Submission ID: 21710

**Our Reference** 60468641 Heckingham Fen DCO

### **Heckington Fen Solar Park DCO – Supplementary Ecology Review**

**From:** Nick Feltham  
**Sent:** 15 August 2023 08:15  
**To:** Heckington Fen Solar  
**Cc:** Peter Udy; Marwood, Abbie (BBC); Laura White  
**Subject:** Heckington Fen Solar Parkn EN010123 - Change Notification Consultation  
**Attachments:** Heckington Solar DCO\_AECOM\_04.08.23.pdf

Project: Heckington Fen Energy Park
 Client: Ecotricity (Heck Fen Solar Park) Limited
 Title: Arboricultural Impact Assessment and Tree Protection Plan (Sheet 1 of 2)
 Drawing number: 22045_502
 Status: FOR INFORMATION
 Drawn By: GW
 Checked By: MR
 Date: 14-06-22
 Scale @ A3: 1:5000

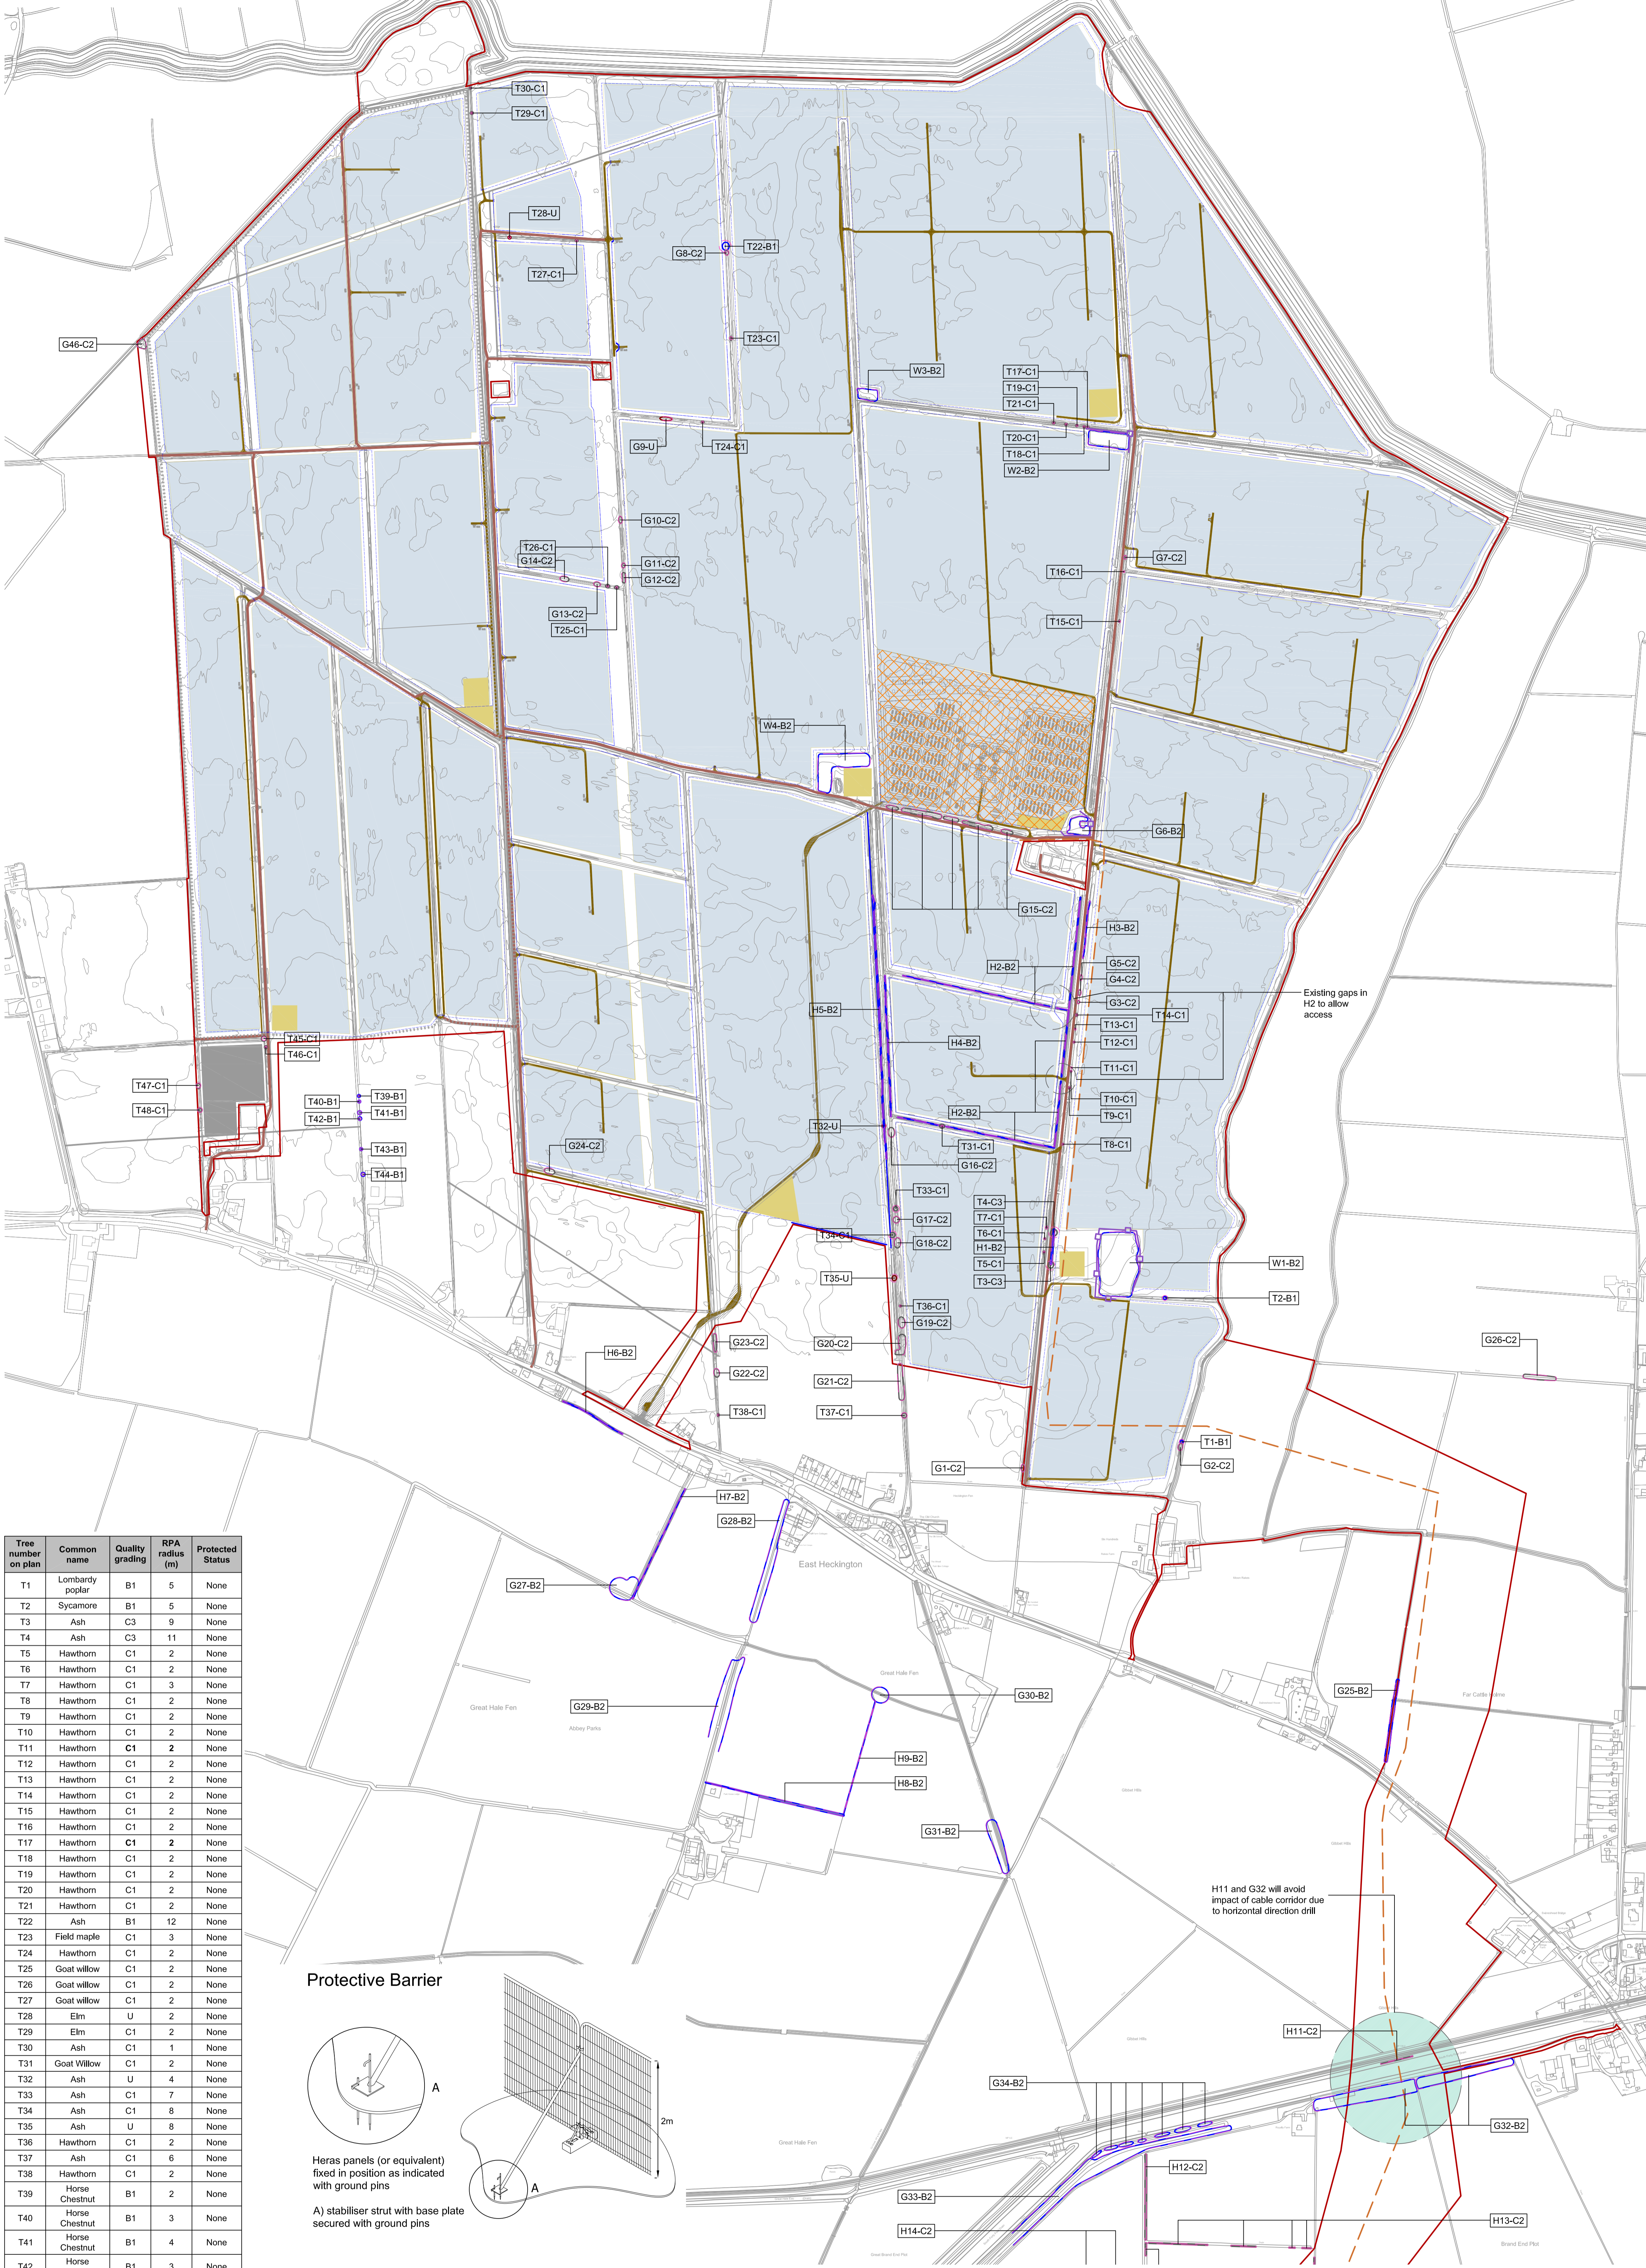
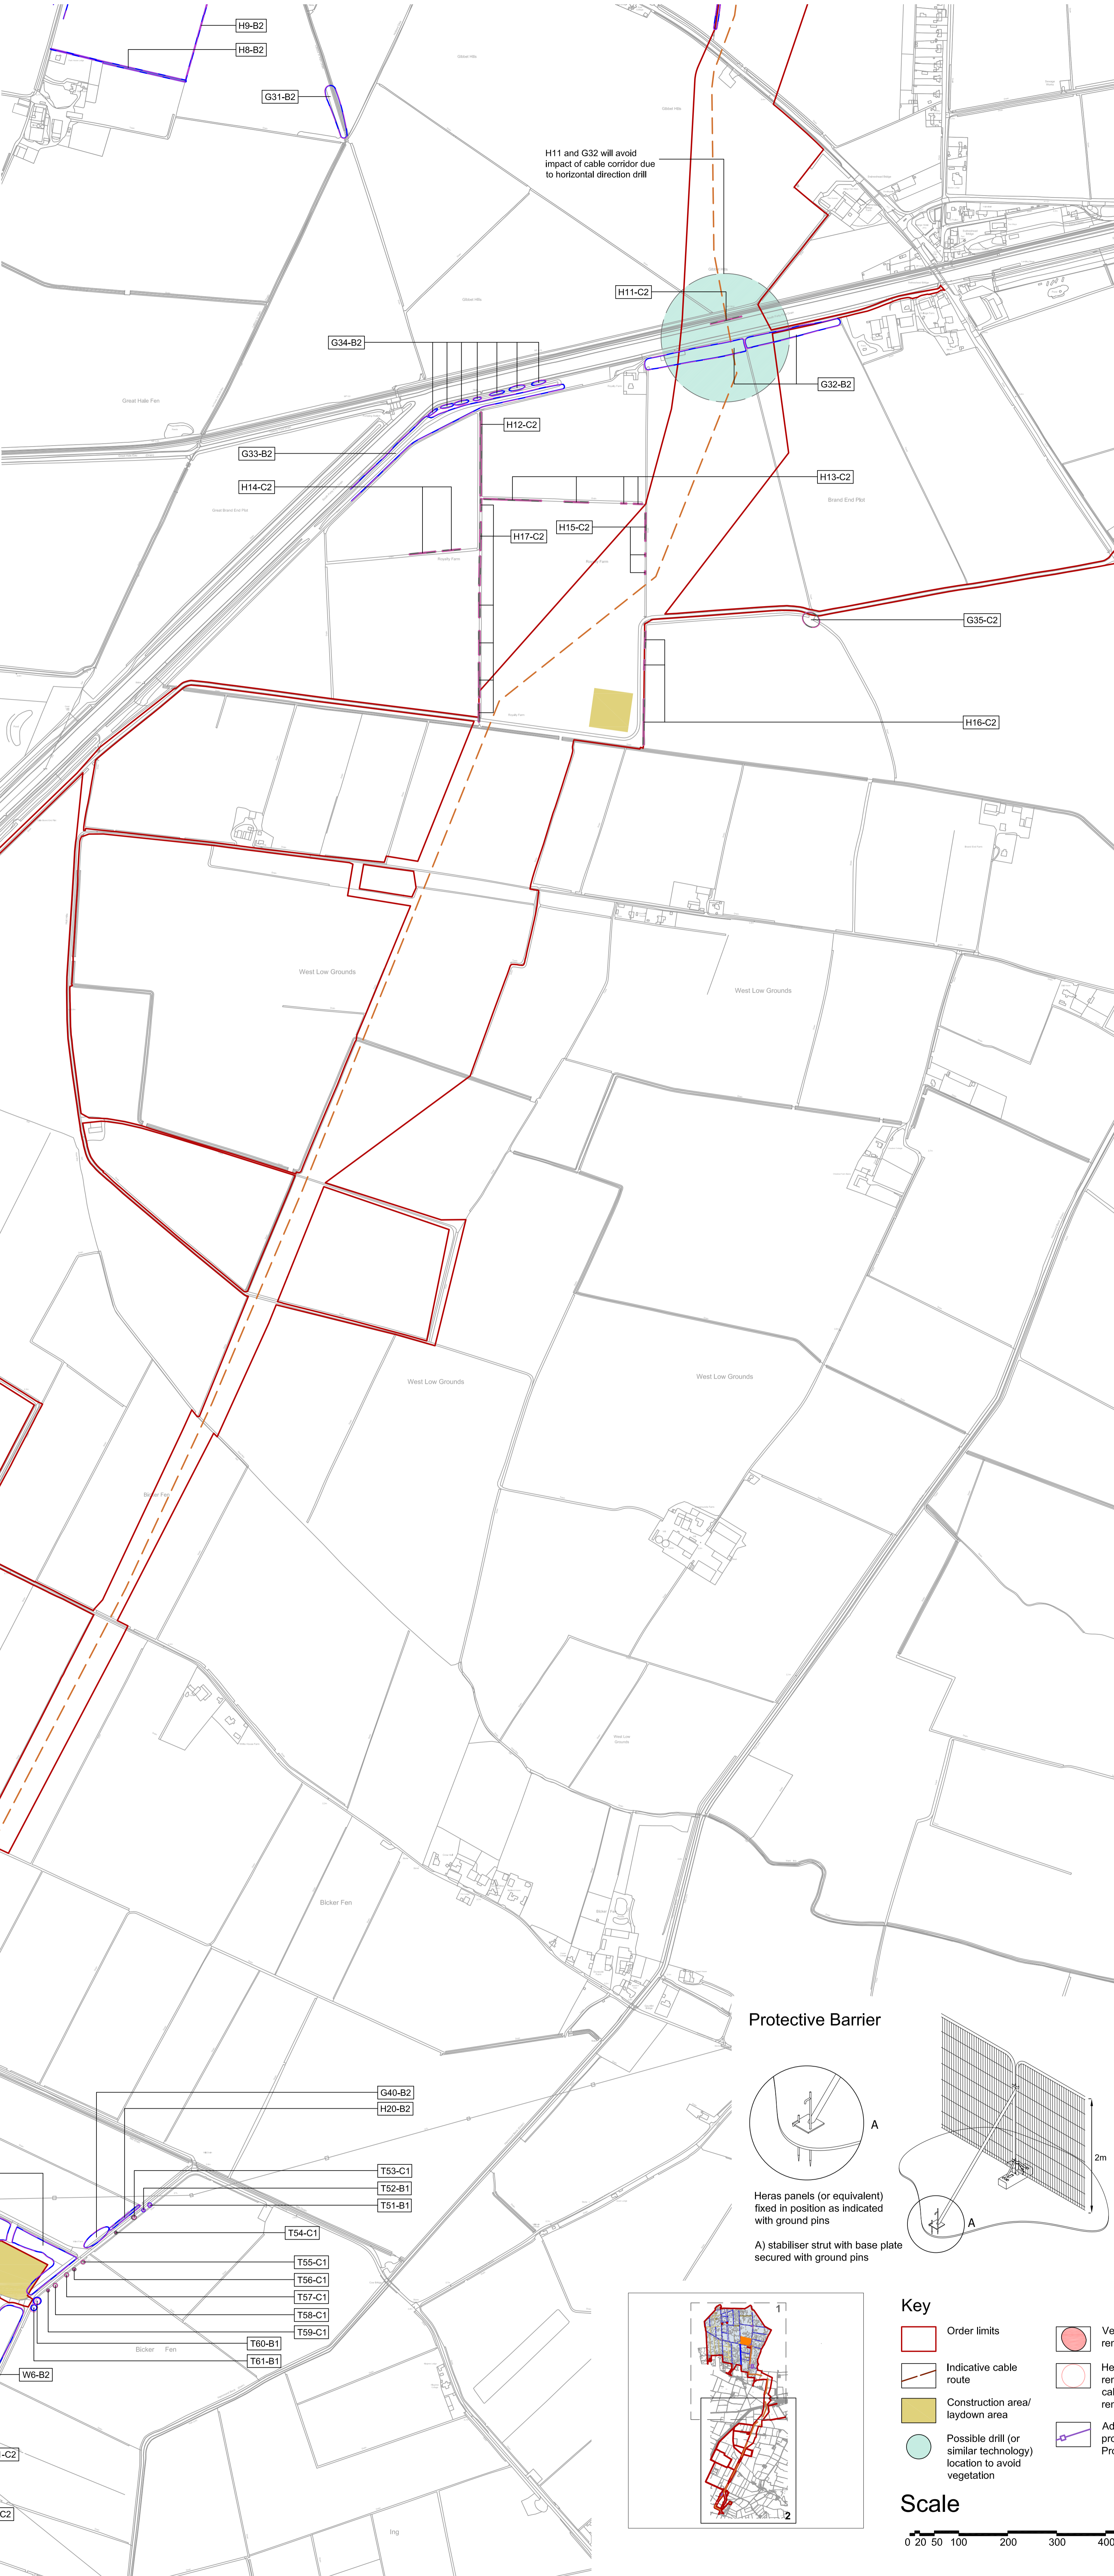
The main additional habitat impact of note is the loss of 4ha of plantation woodland comprised of native tree species (the submitted plans indicate this would be over 50% of the affected woodland). The South East Lincolnshire Local Plan states (paragraph 7.5.11) that there is little woodland in South East Lincolnshire. Therefore, I do not agree with the assessment that the woodland is of local nature conservation value only. Given the scarcity of woodland in the Local Plan area, district/borough value would seem most appropriate in accordance with the method statement in Section 8.3 of Chapter 8 of the Environmental Statement (ES).

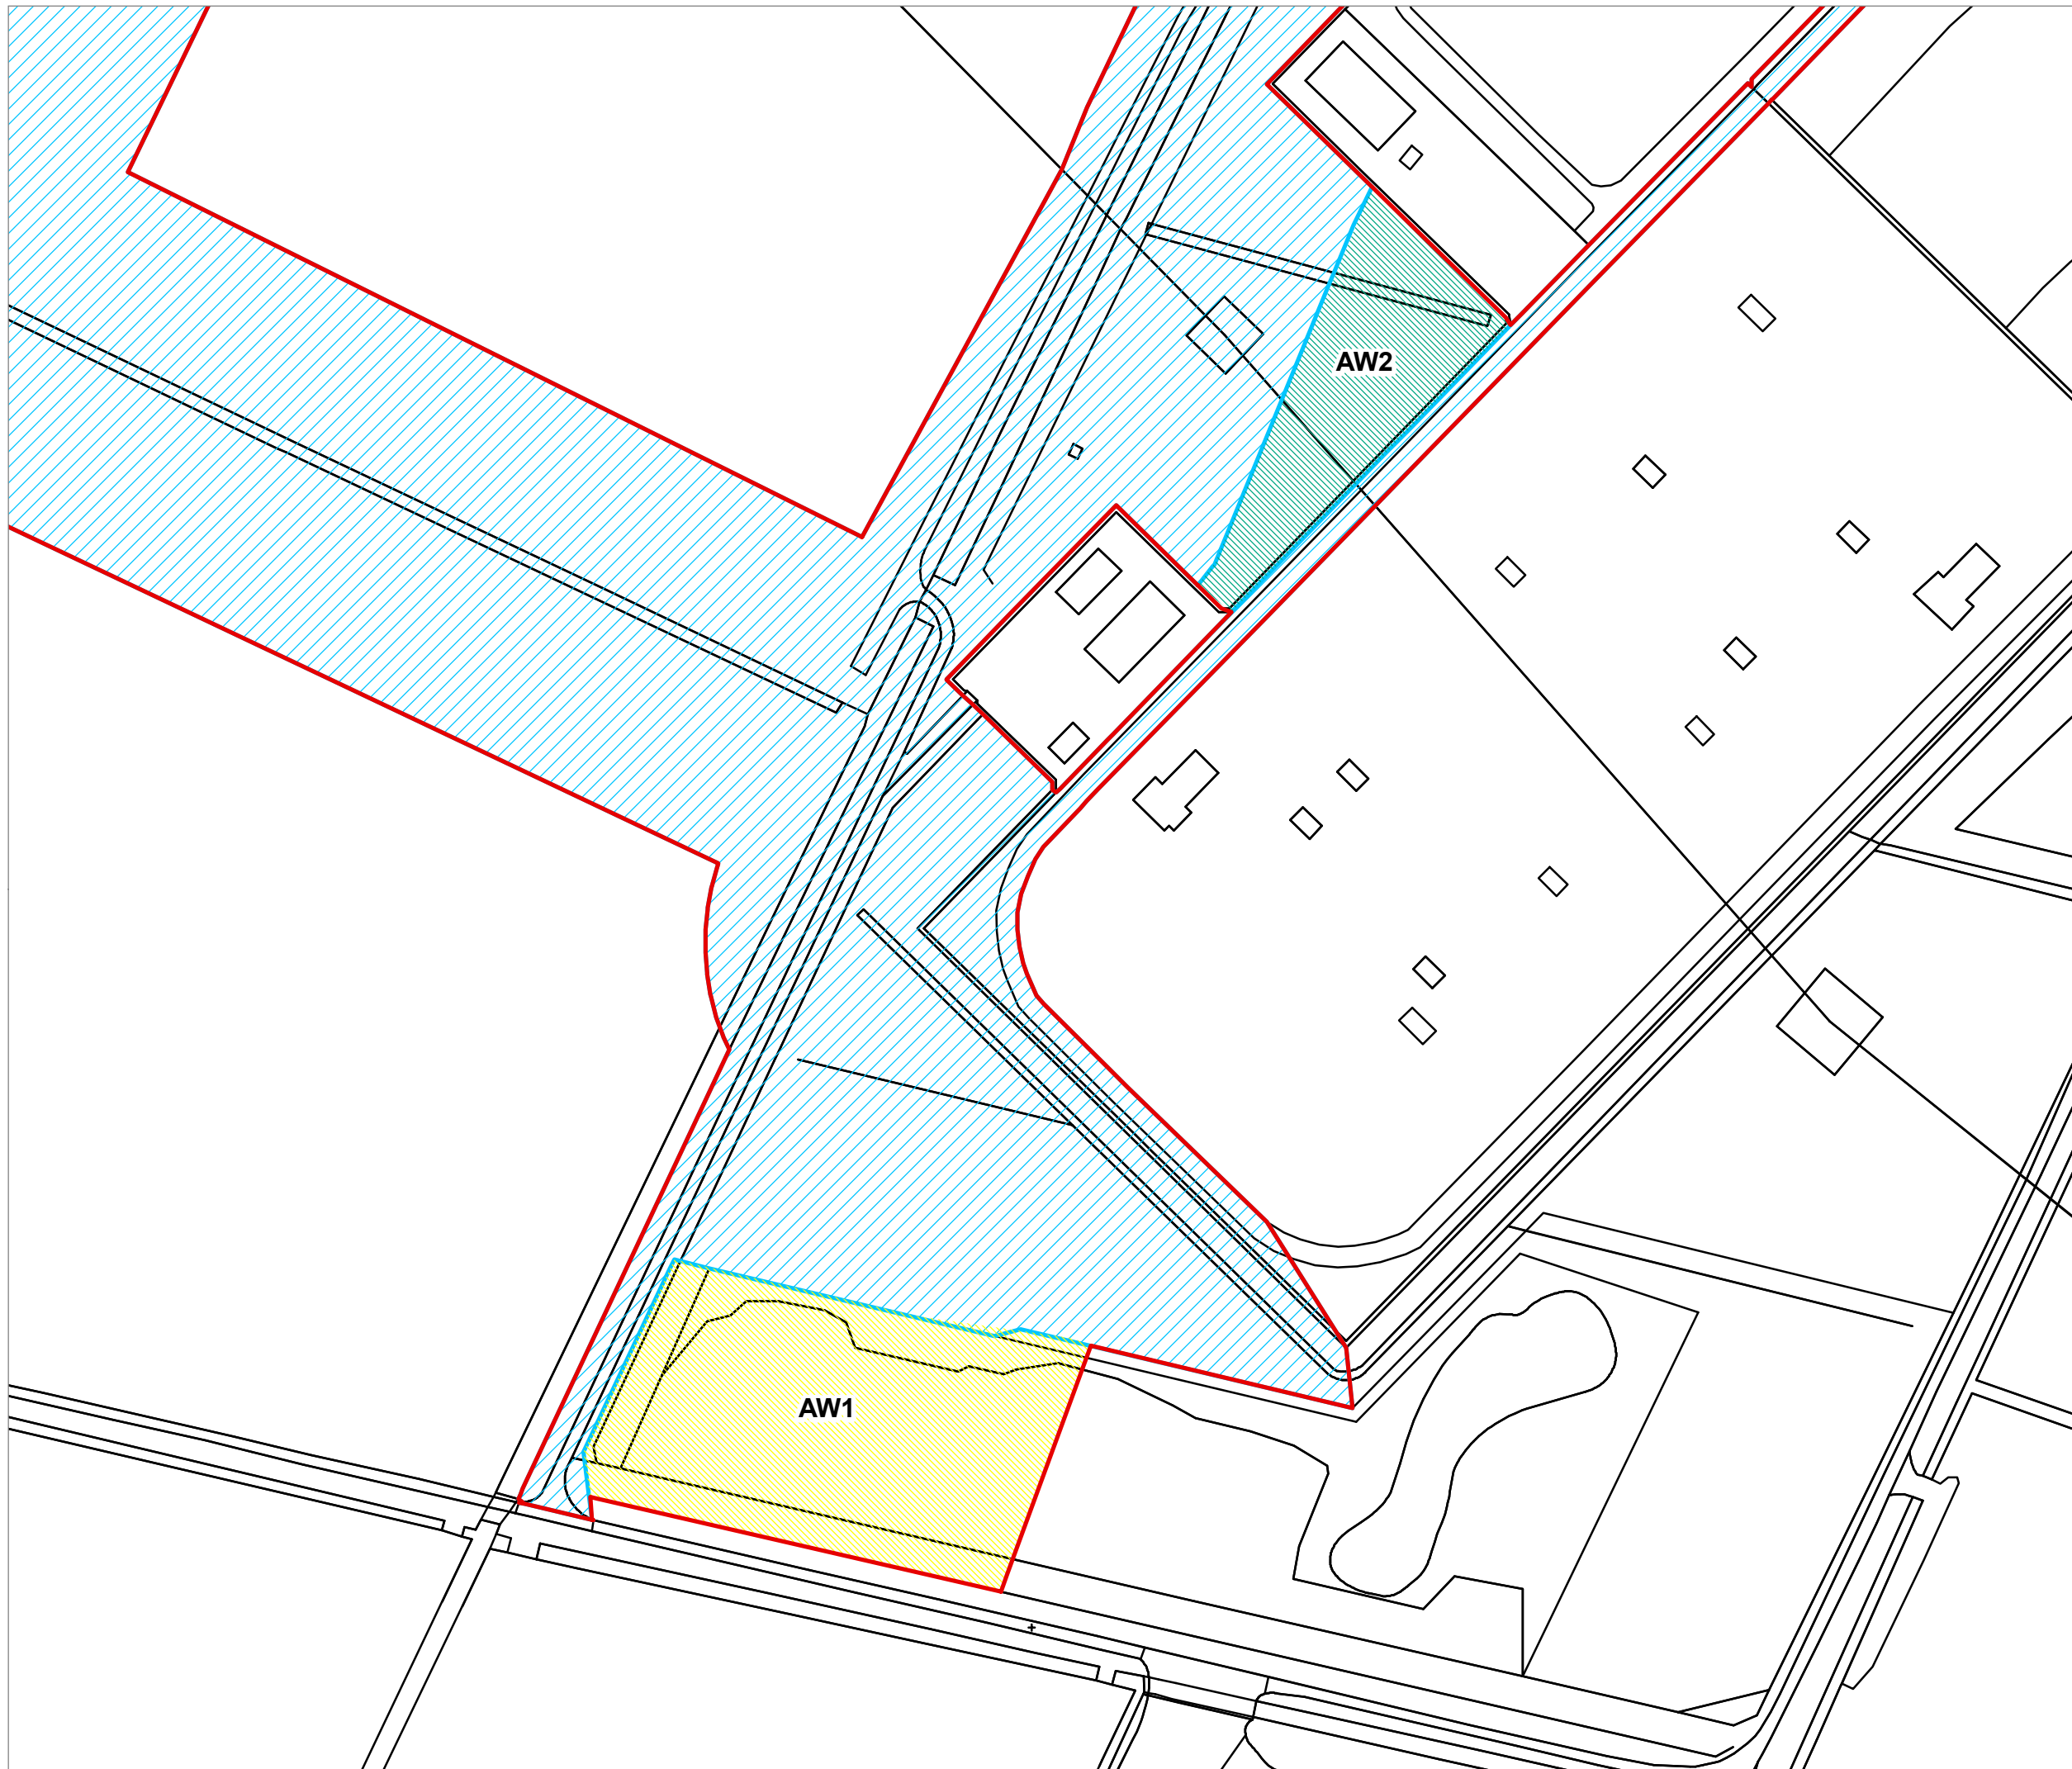
I have reviewed the implications arising from the proposed minor order limits change in the vicinity of Bicker substation within the borough of Boston. This change would result in further localised permanent losses of semi-natural habitats adjacent to the substation. The time series of aerial imagery available via Google Earth shows these habitats to be of secondary origin and in the order of 18 years of age, originating c. 2005-2007 at the time of construction of the substation.

Local Plan Policy 28 includes a presumption that existing woodland will be protected. If the need for the woodland loss can be demonstrated (after first considering options for impact avoidance and reduction), habitat compensation will be required. It would take a prolonged period of time to re-establish woodland of comparable structure and condition i.e. upwards of 18 years. Further, if the existing woodland was retained it would continue to mature and accrue biodiversity value. So, even after 18 years of growth, the new woodland would not have the same biodiversity value as the existing woodland if it was retained.

If the need for the woodland loss is accepted, then the required level of compensation should be determined by the Biodiversity Net Gain (BNG) assessment. This compensation should preferably be located in close proximity to the woodland loss, given the scarcity of woodland within the affected landscape. New woodland creation should not be at the expense of other habitats of existing biodiversity value. My prior comments in relation to the BNG assessment should be considered when updating the assessment to include the additional habitat losses.
